MORGAN AND MORECAMBE OFFSHORE WIND FARMS: TRANSMISSION ASSETS

Applicants' Response to Deadline 5 submissions from Statutory Consultees and other organisations

Document Reference: S_D6_2
F01

22 October 2025

Figure 1.19a: Undefended 1% AEP joint probability event plus 20% climate change uplift event

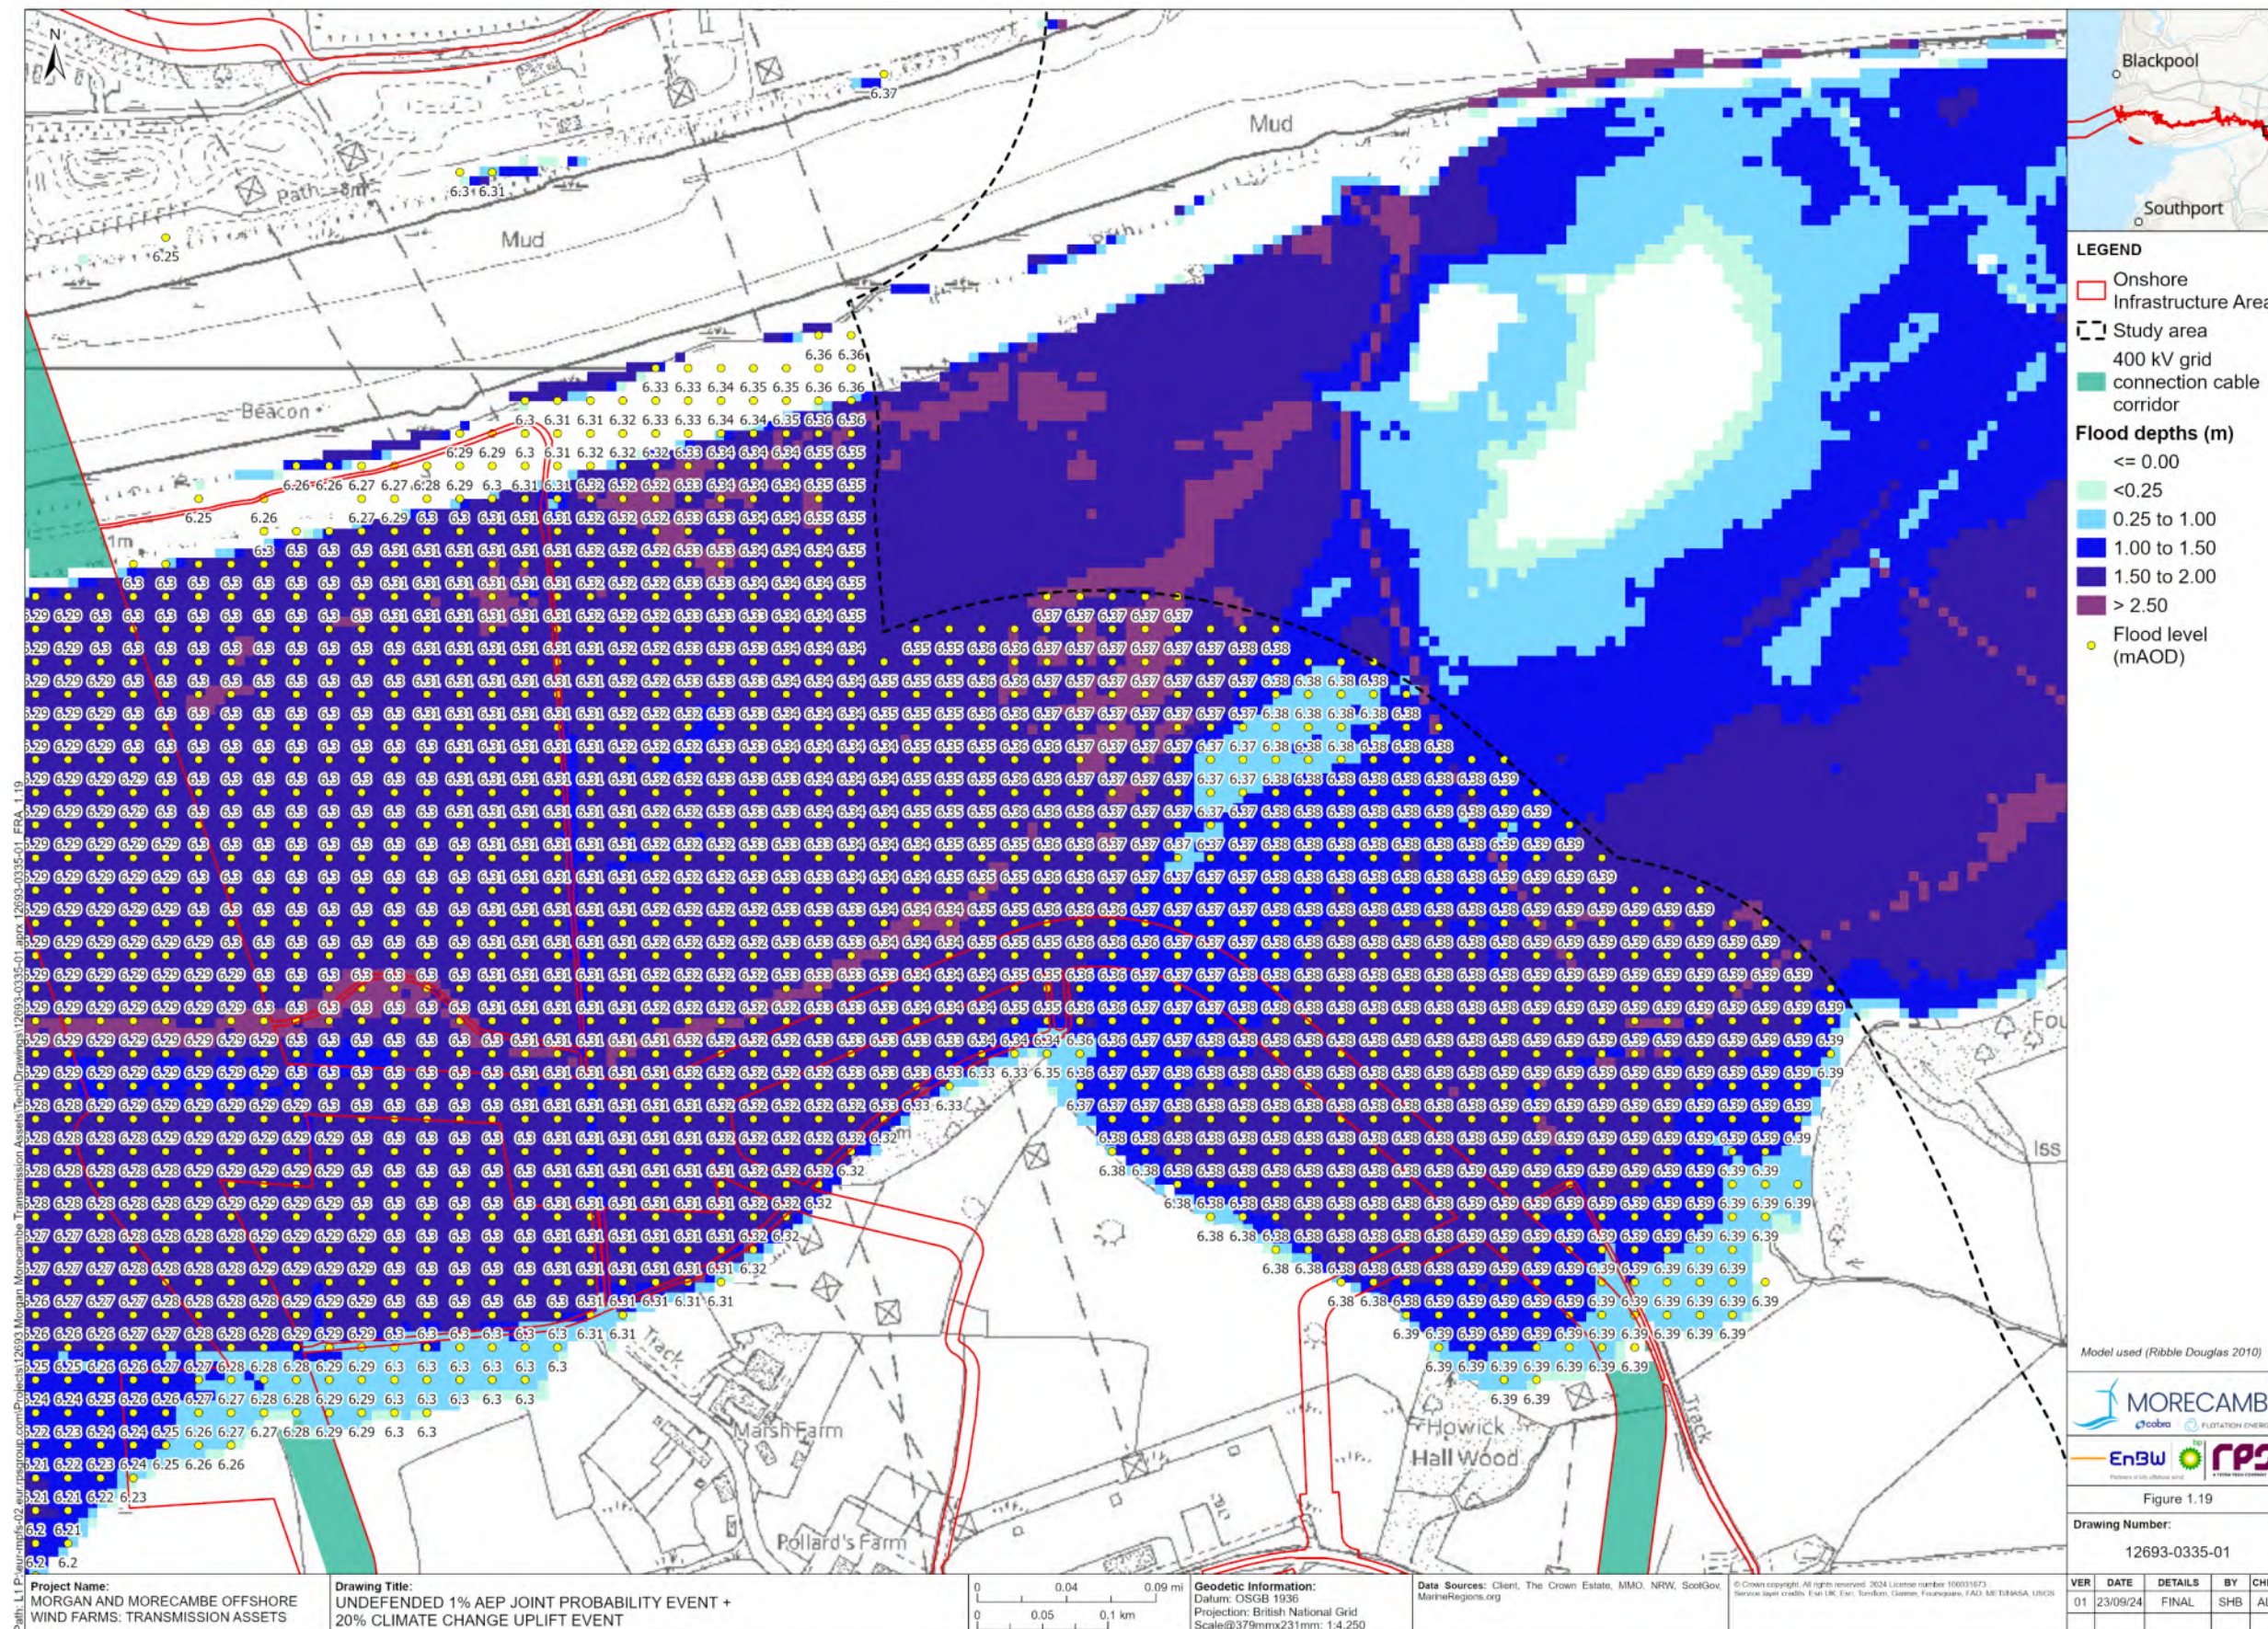
REP5-168	<p>Volume 3, Annex 2.3: Flood risk assessment - part 2</p>	<p>The Applicants note this comment and confirm that the discrepancy only appeared on the tracked version and therefore, no changes were required. The</p>

Reference	IP submission	Applicants' response
168.9	<p>Pages 163- 166</p> <p>Issue: Changing in titles and figure numbers appears to have resulted in a discrepancy between the new figure label in the report and the figure reference in the original title box of the drawing.</p> <p>Impact: This makes references somewhat problematic and confusing.</p> <p>Solution: Clerical error requiring correction</p>	<p>Applicants have ensured that all figure references and numbers are consistent. An updated version of volume 3, Annex 2.3: Flood risk assessment (F3.2.3/F03) has been submitted at Deadline 6.</p>
REP5-168 168.10	<p>Volume 3, Annex 2.3: Flood risk assessment part 3</p> <p>Issue: Like previous comments.</p> <p>Changing in titles and figure numbers appears to have resulted in a discrepancy between the new figure label in the report and the figure reference in the original title box of the drawing.</p> <p>e.g. Figure 1.23: Undefended 1% AEP fluvial event plus 20% climate change uplift on Page 199 is figure 1.17 in the drawing title box.</p> <p>Impact: This makes referencing somewhat problematic and confusing.</p> <p>Solution: Clerical error requiring correction</p>	<p>The Applicants note this comment and have updated all figure references and numbers where appropriate. An updated version of volume 3, Annex 2.3: Flood risk assessment (F3.2.3/F03) has been submitted at Deadline 6.</p>
